Architecture and Landscape Section 4.55 Modification  
Port Macquarie Campus

Project	Hastings Secondary College	Code	HSPM
Organisation	FJMT	Revision	1
To	Bill Rushworth	Date	14/04/2022
		Doc Number	A-000055

title
General Arrangement Plans
General Arrangement Plan - CAPA & New Link Roof Plan

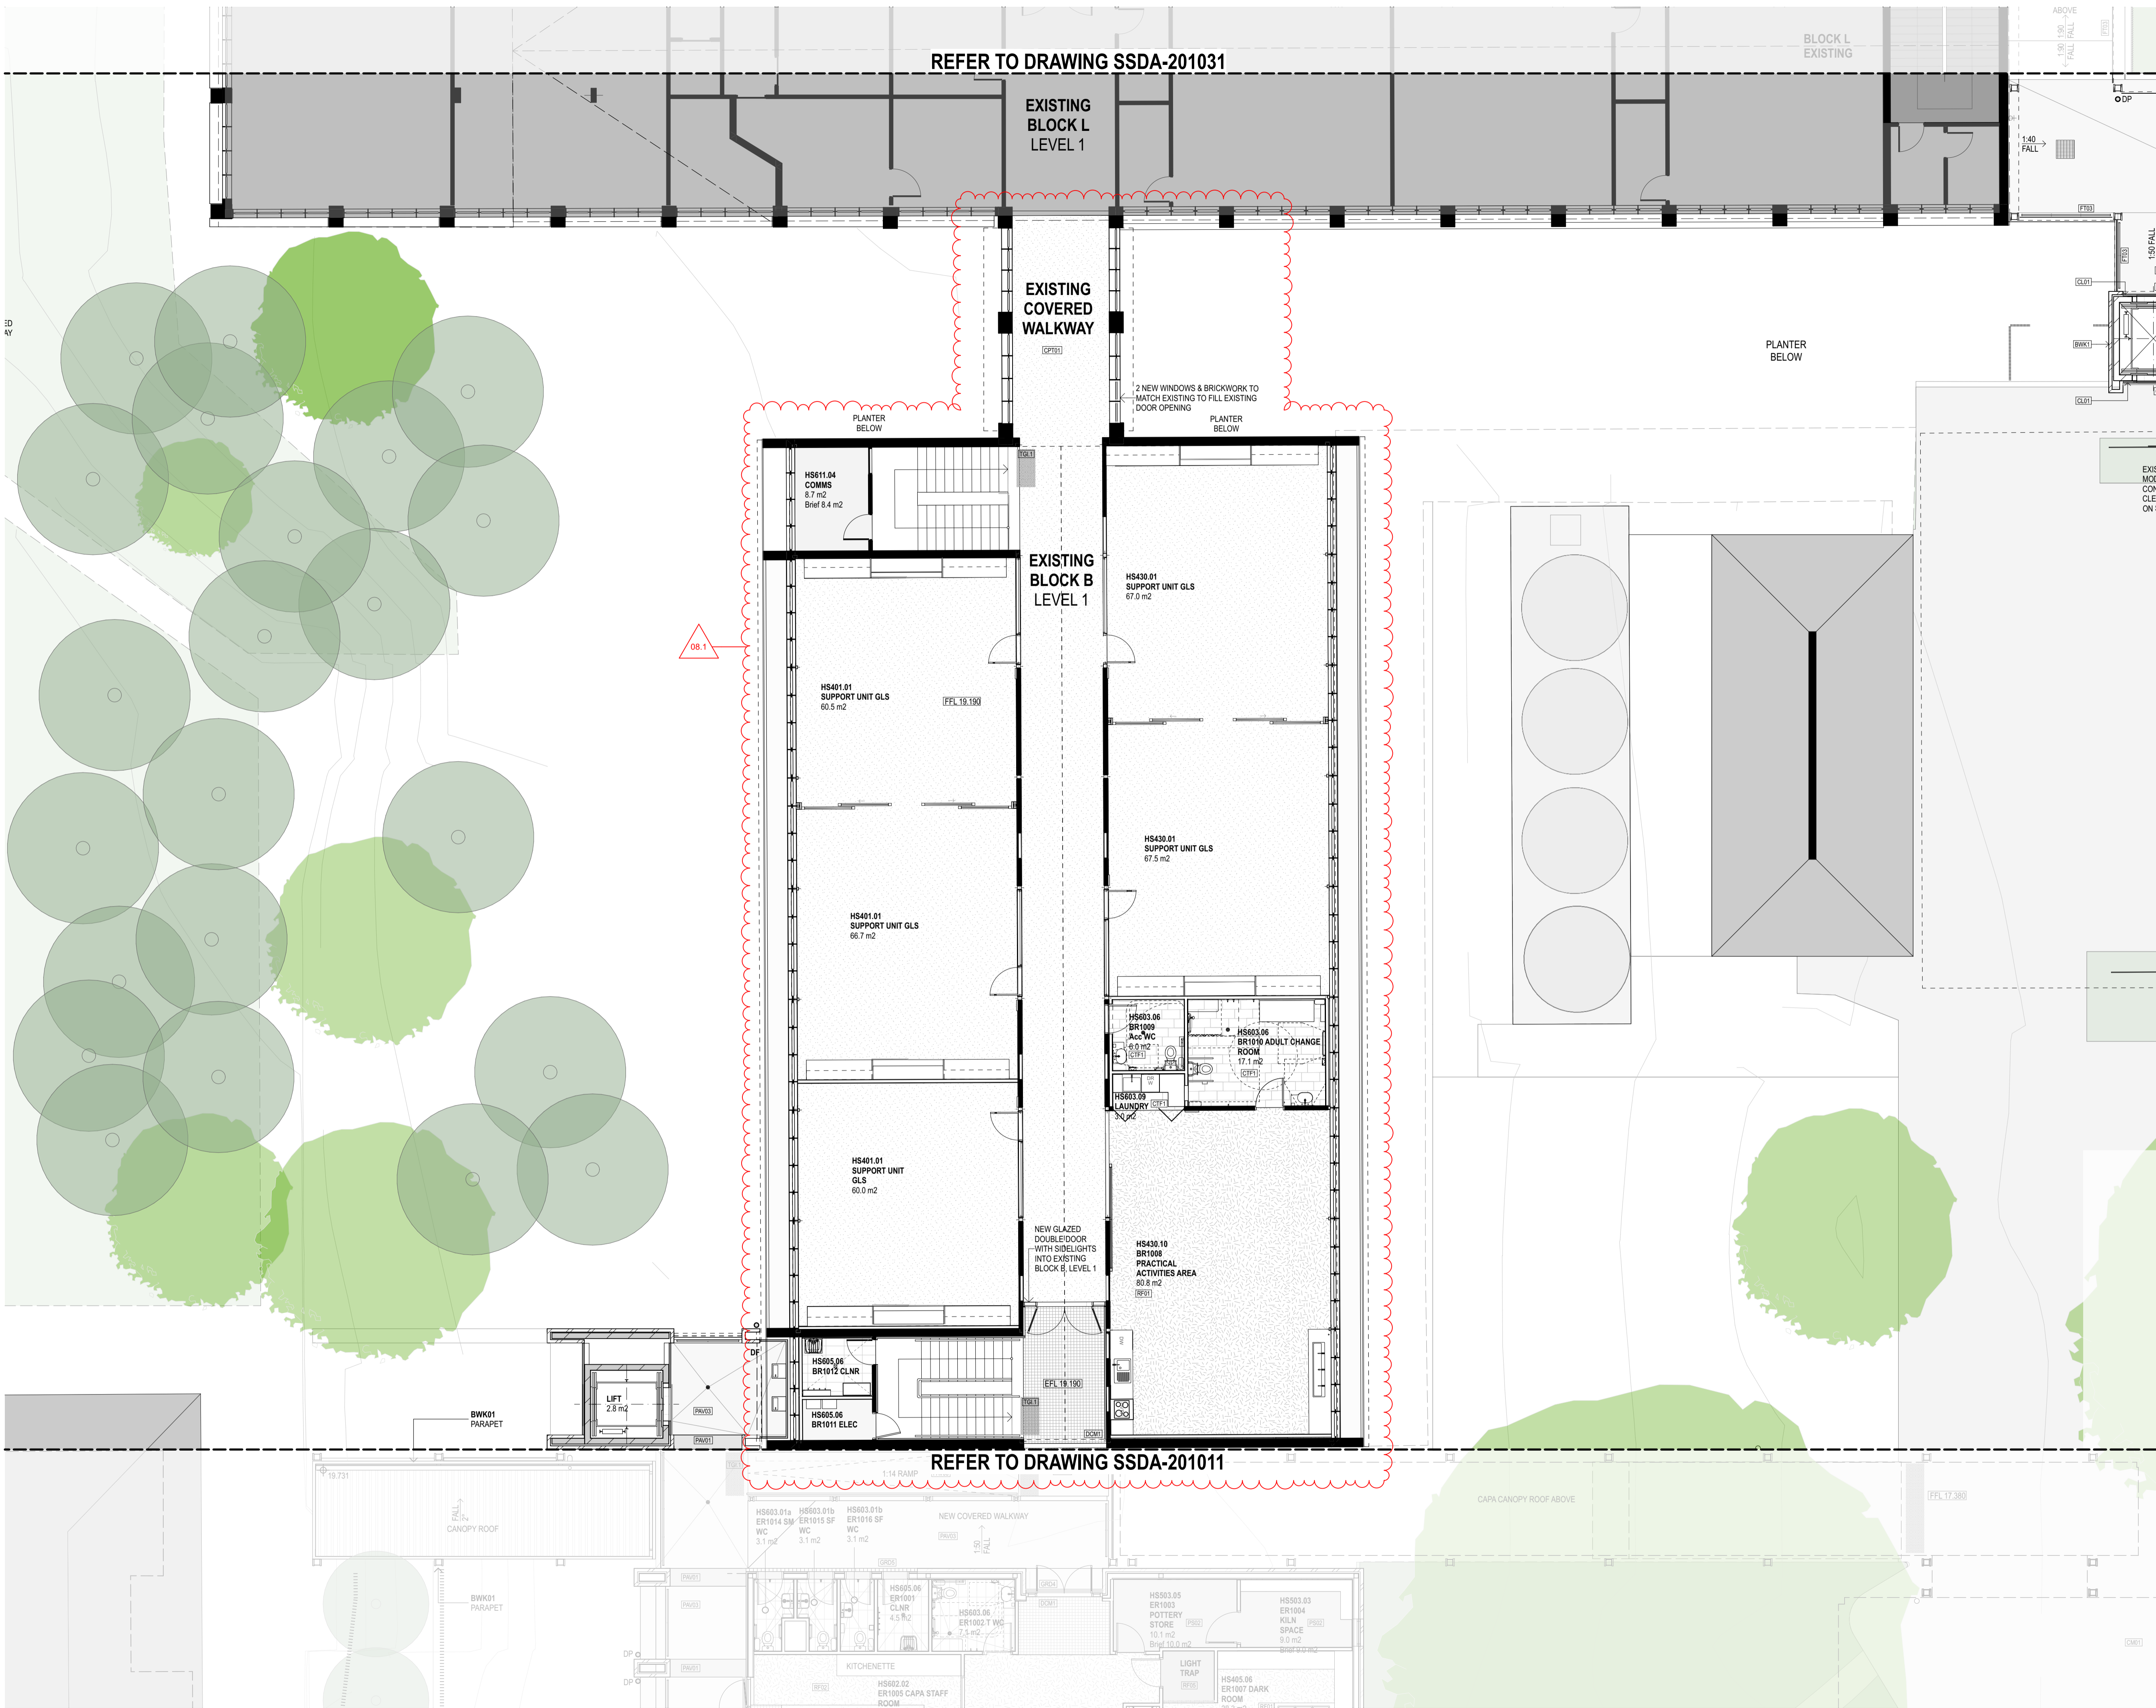
7.2	New painted steel egress stairs to access Level 1 terrace. Minor changes to the northern face to accommodate this change.
SSDA 201012	06	General Arrangement Plan - CAPA & New Link Roof Plan	6.1	Further co ordination and resolution of external plant.

6.2	Location of Photo Voltaic Panels (as previously approved) identified on roof. Minor services penetrations - note, both are located under the parapet line.
SSDA 201020	08	General Arrangement Plan - Building B Refurbishment Level 1 Plan	8.1	Relocation of Supported Learning (previously in Ground Level Building L) to provide a better connectivity with adjacent departments.
SSDA 201030	06	General Arrangement Plan - Building L Refurbishment Ground Floor Plan	6.1	Relocation of Supported Learning to provide a better connectivity with adjacent departments. No work to this zone.

1 PLAN North South Link level 1
1:100

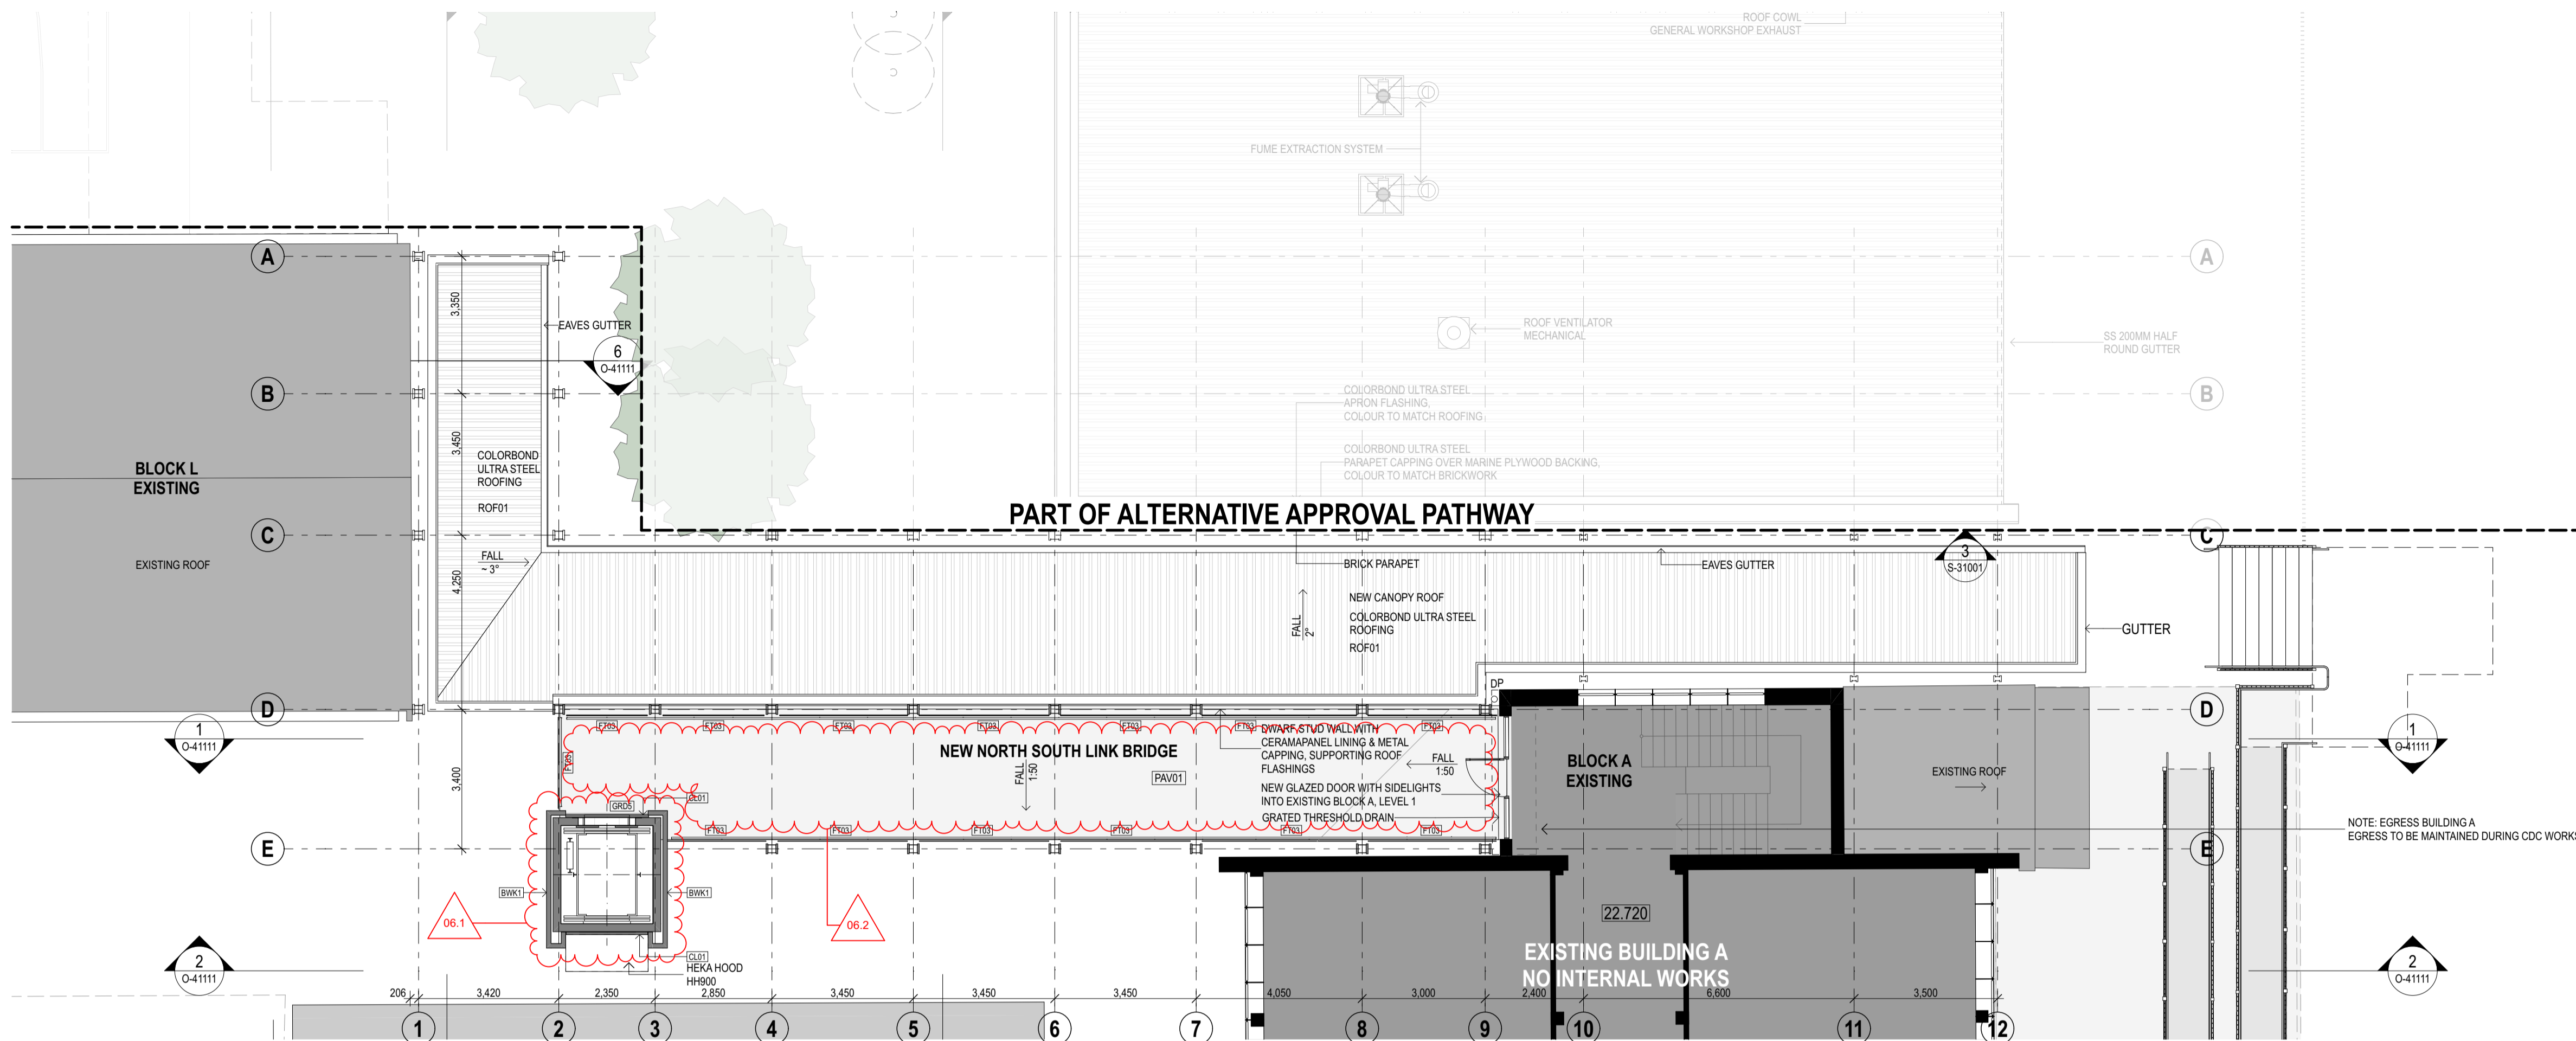
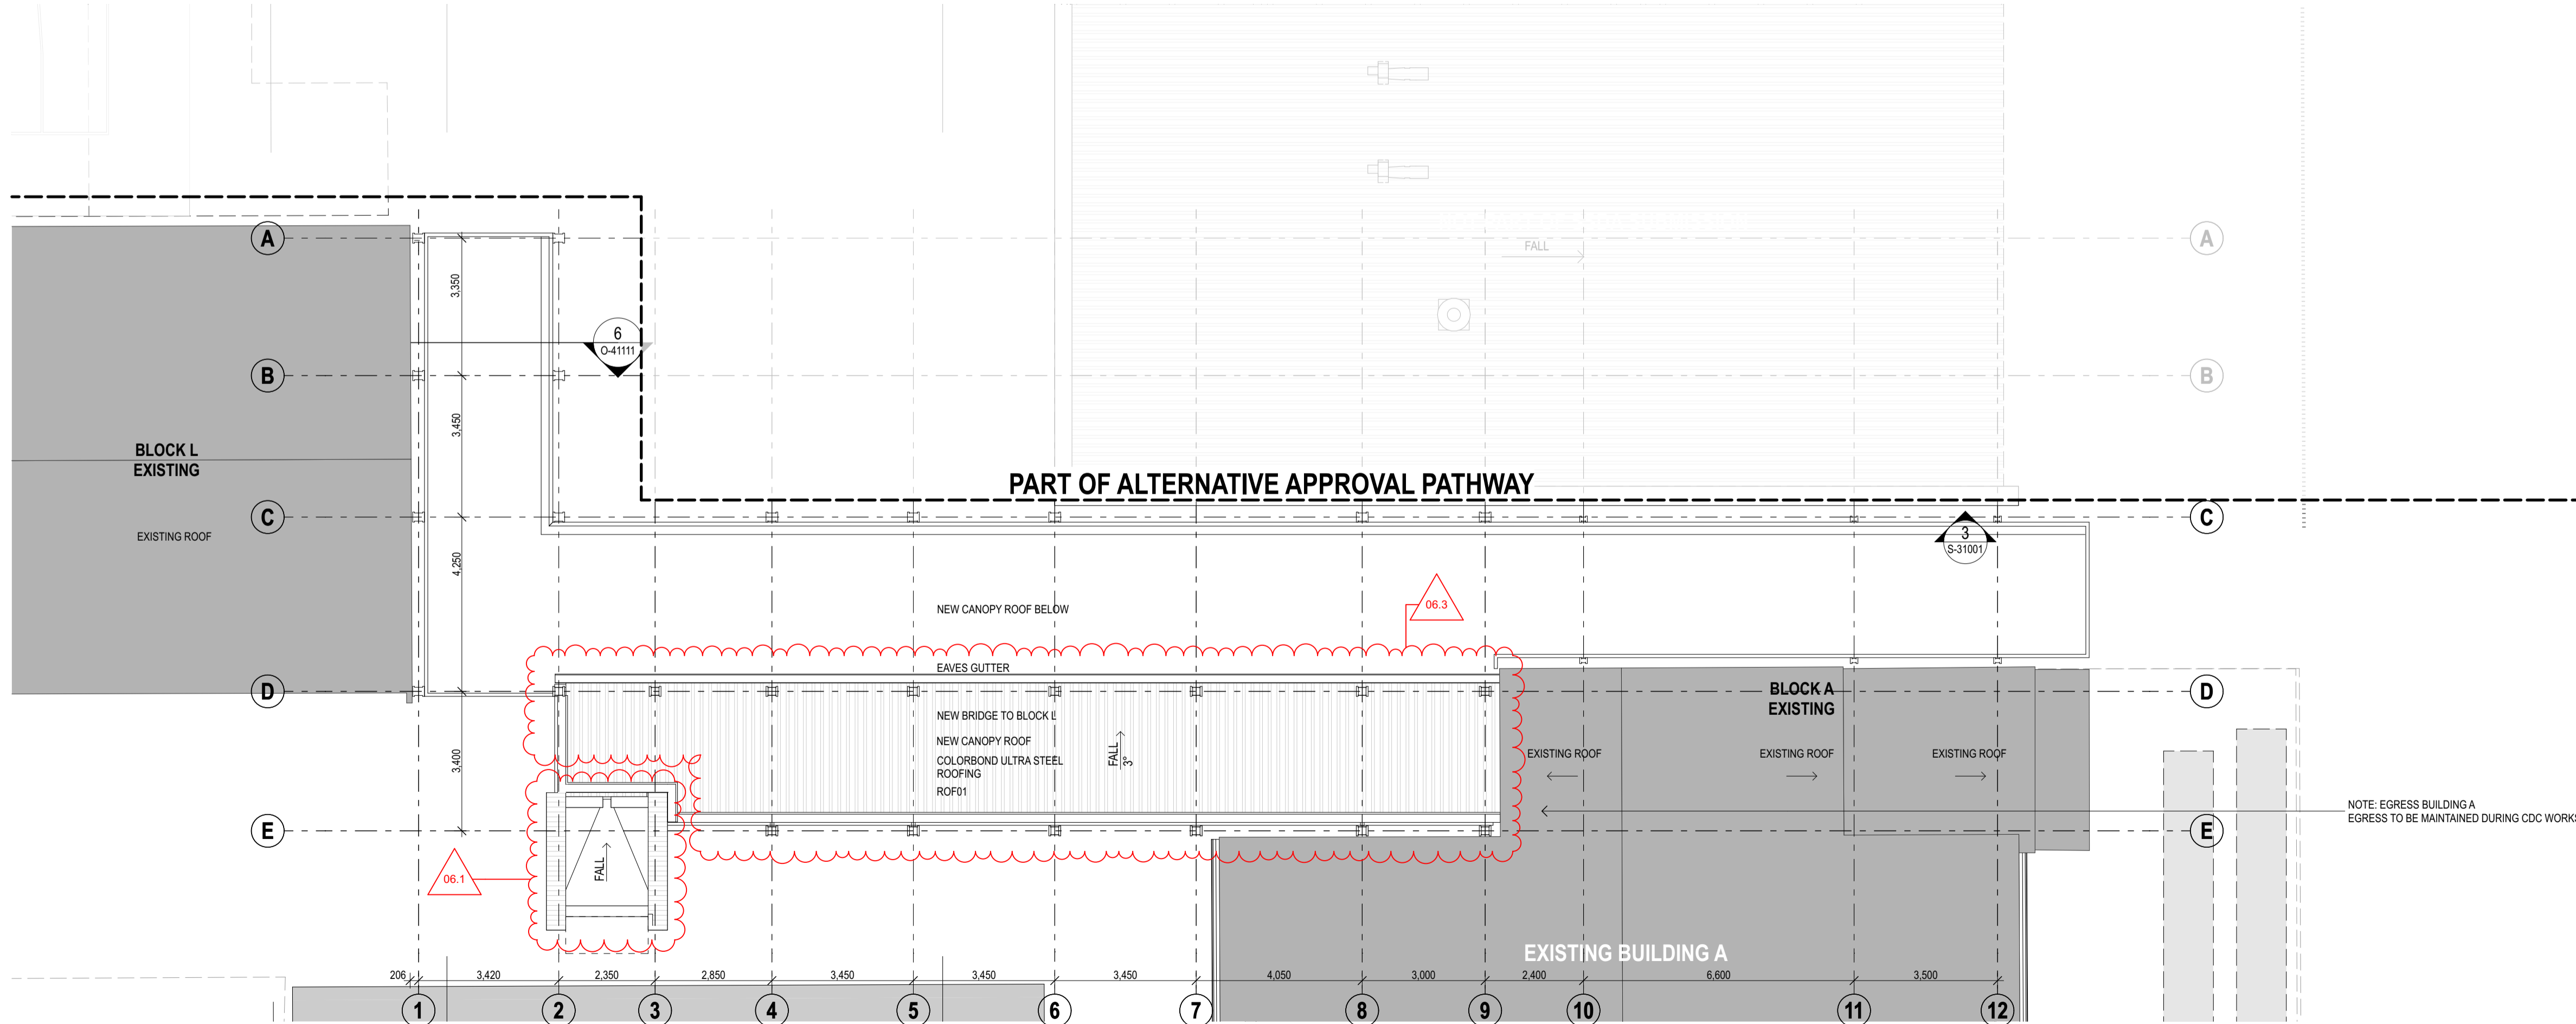
6.2	Minor adjustment to external levels to meet “as built” survey
			6.3	Adjustment to external stairs to avoid existing site services. (Grease arrestor)
SSDA 201061	06	General Arrangement Plan - North South Link Level 1 Plan	6.1	Minor dimensional adjustment to lift. Materiality revised from off form concrete to brickwork and compressed fibre cement cladding.

6.2	Minor adjustment to lift and associated walkway to meet build ability requirements.
			6.3	Minor adjustment to lift and associated walkway to meet build ability requirements.
SSDA 201070	05	General Arrangement Plan - School Entry Canopy Plan	5.1	Revision to entrance sequence including the reinstatement of the existing entry stairs and relocation of ramp to provide a more equitable response.
